From: Martin Hill <Martin.Hill@arun.gov.uk>
Sent: 19 April 2022 12:37
To: Planning.Responses <Planning.Responses@arun.gov.uk>
Subject: RE: Planning Consultation on: BR/82/22/PL

Comments from Private Sector Housing:

Application No: BR/82/22/PL
Registered: 11th April 2022
Site Address: Holmlea, Main Unit Rear Of Town Cross Avenue Bognor Regis PO21 2DN
Grid Reference: 493120 99926
Description of Works: Demolition of warehouse and proposed construction of 10 self contained apartments. This application is in CIL Zone 4 (Zero Rated) as flats.

Proposed Apartments
Planning

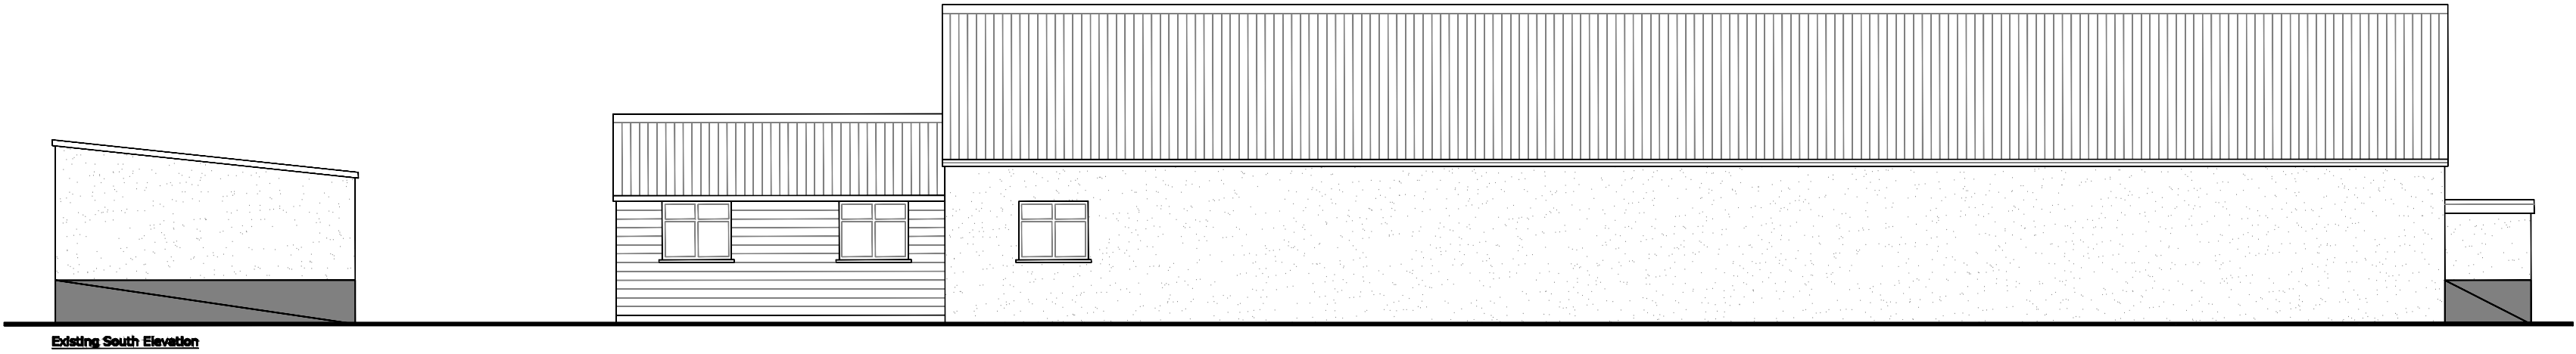
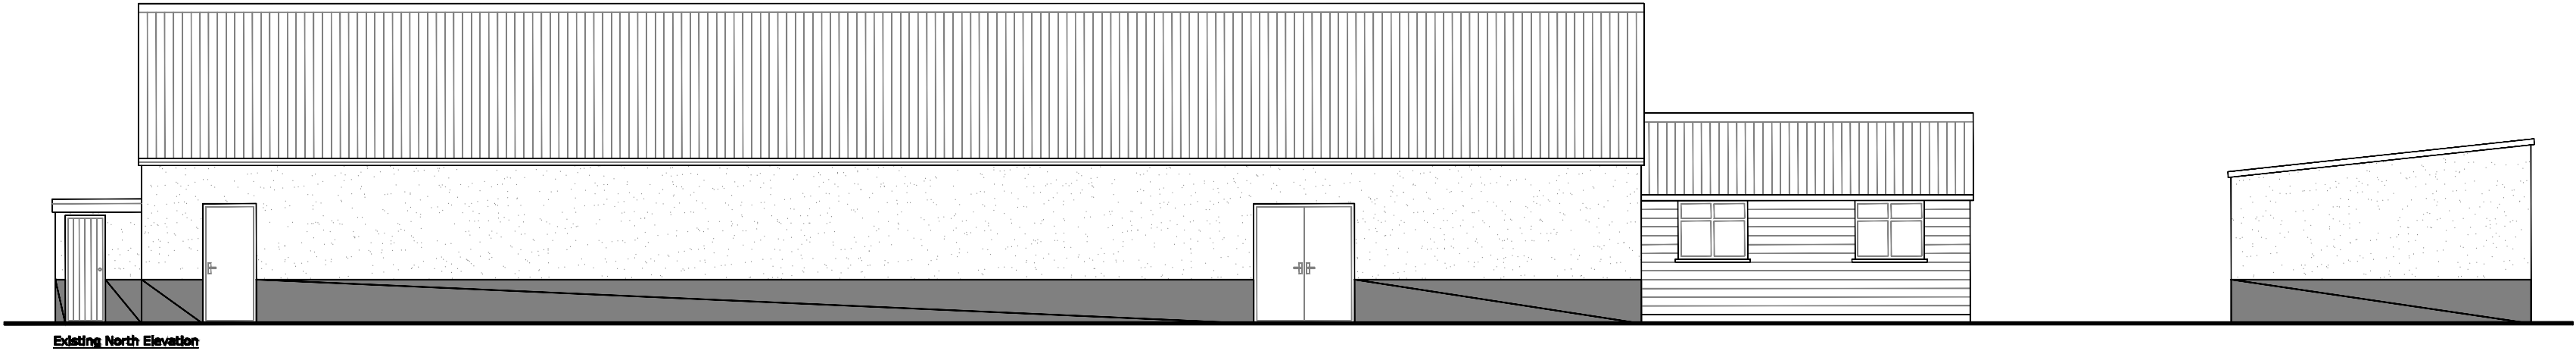
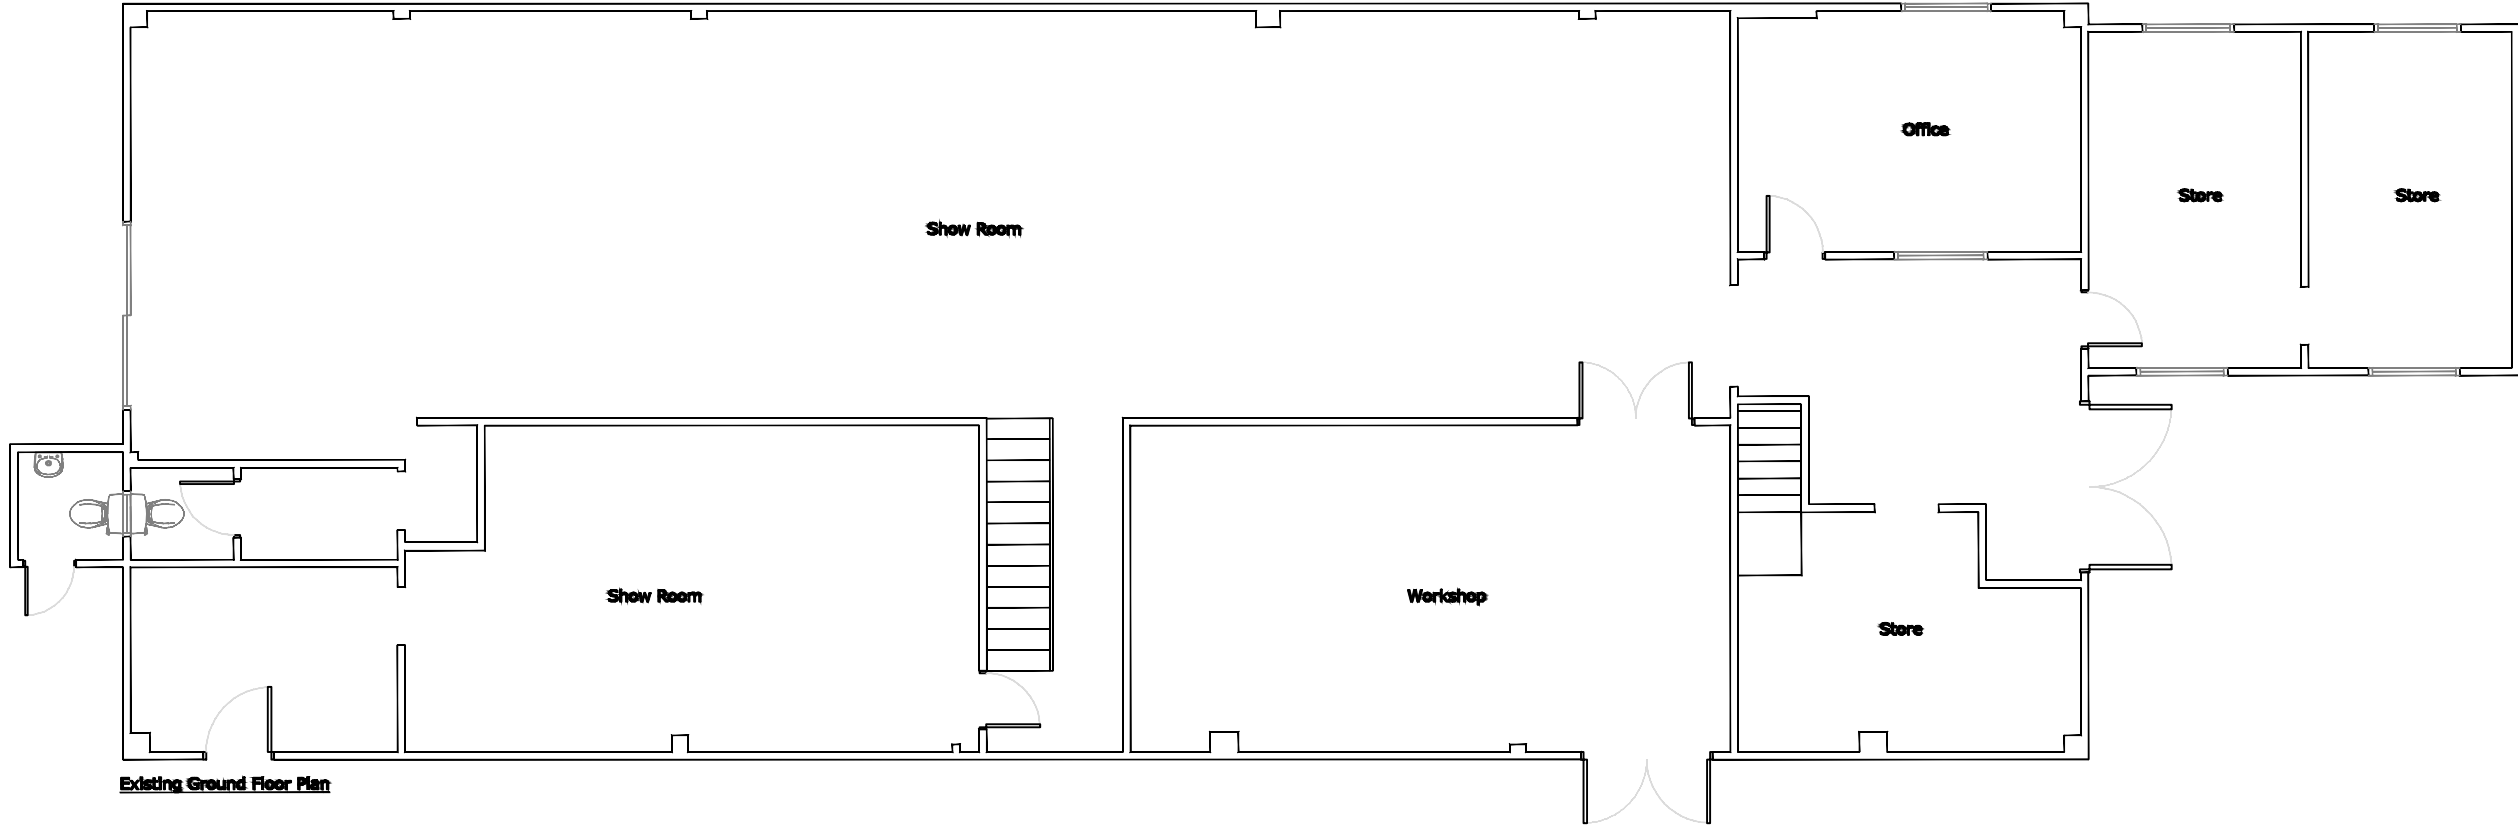
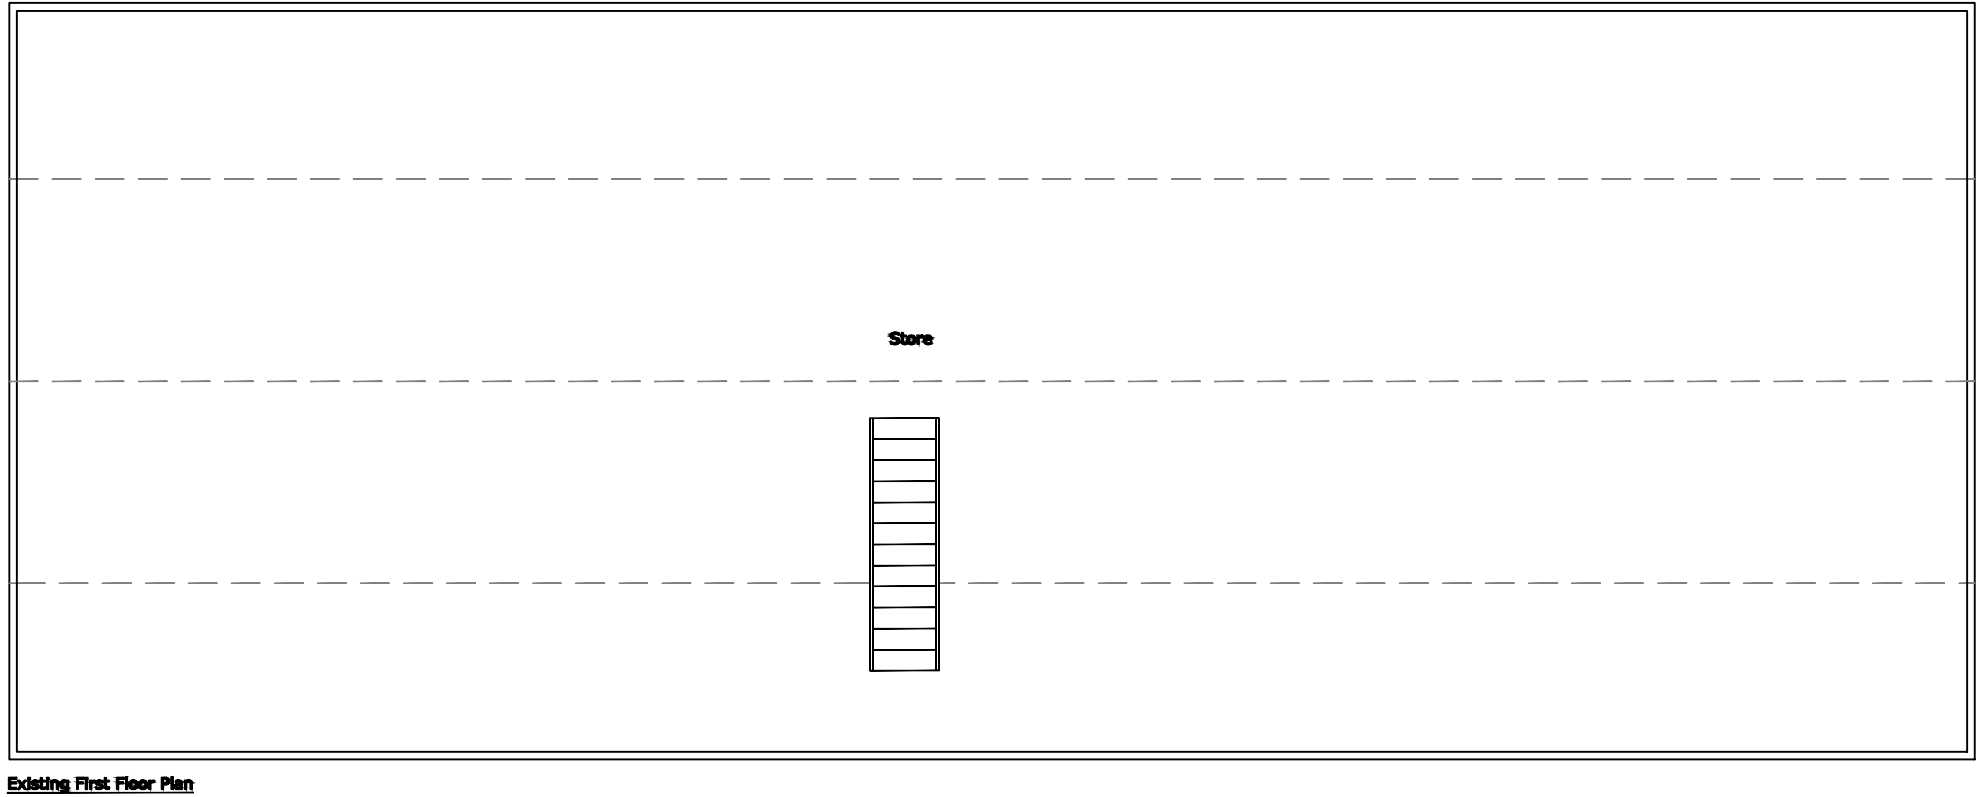
- A room where the only escape route is through another room is termed an “inner room” and poses a risk to its occupiers if a fire starts unnoticed in the outer room. The escape routes from all flats, with the exception of flats 2 & 3 are all via an outer risk room, such as a living room and kitchen. Reconfiguration should be considered so as to provide an entrance hall within each flat and each risk area portioned off from the next, with an independent access door to each room from the hallway. Examples of this can be taken from the proposals for flats 2 & 3. This is considered the only option for flats 9 & 10 on the second floor. Alternative, but less ideal options for the ground and first floor flats with inner room situations, could include meeting the LACoRS requirements for inner rooms, which would include an FD30S fire door fitted to the bedroom doors which separates the inner and outer

rooms, together with an emergency escape window and interlinked automatic smoke detectors located in both the inner and out rooms. It this can be overcome by ensuring that the window in the living/bedroom is an escape window and adequate fire protection within the flat. An escape window is not acceptable above 4.5m above ground level, hence the layout of flats 9 and 10 needing to be reconsidered/reconfigured. When relying on an emergency escape window serving a room, a safe escape external escape route must be assured at all times with level ground below, unobstructed, and the route leading to a place of ultimate safety.

- Any bathrooms and kitchens without windows for natural ventilation should have adequate mechanical ventilation. It is understood skylights may be present in kitchen areas of flats 9 & 10 – if these are not easily and readily openable, mechanical extraction must be installed in the kitchens of flats 9 & 10.
- All habitable rooms must have an opening window, equivalent to 1/20th of the floor area, to the outside air to provide adequate ventilation. French or patio doors that have no separate openable casements, or where there is no alternative openable casement within the room, are not considered acceptable in bedrooms.
